From: Andrew Wood
Sent: 11 April 2019 17:13
To: Planning.Responses
Subject: FW: AL/31/19/HH - 16 Church Road, Aldingbourne - Windows
Attachments: 3034.19.1 Rev D.pdf

AL/31/19/HH - 16 Church Road, Aldingbourne – Front Windows

Proposed Front
1 : 100

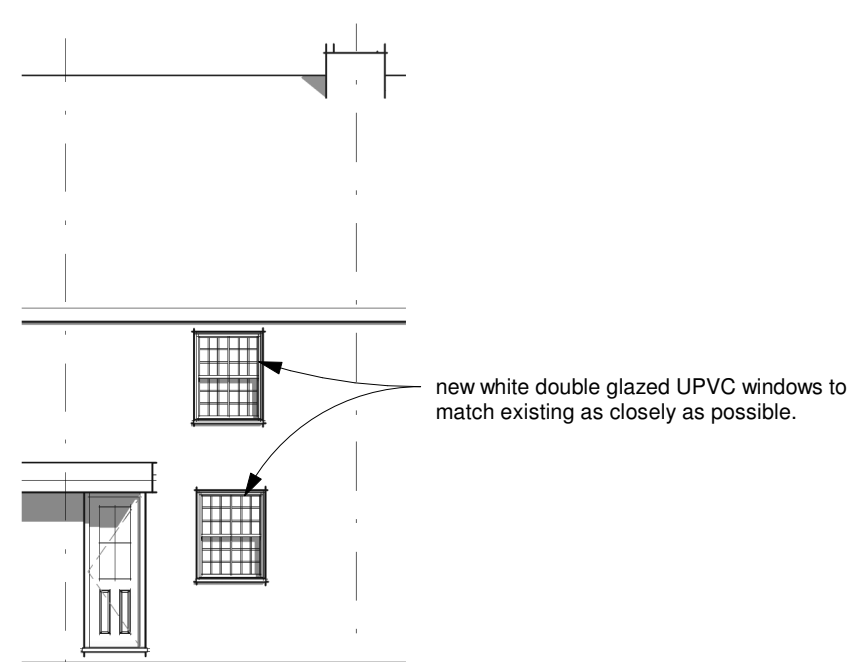
I am not satisfied that sufficient detail regarding the front windows has been supplied in this application as yet.

Both neighbouring properties have good quality well maintained wooden cottage style windows in their front elevations.

My preference would be for cottage style wooden framed windows with slimline double glazed panels. If the client is insistent upon UPVC framed windows the details of exactly which UPVC windows would need to be considered prior to making a decision on the application to avoid an outright refusal of the application as contrary to policies relating to design and historic environment.
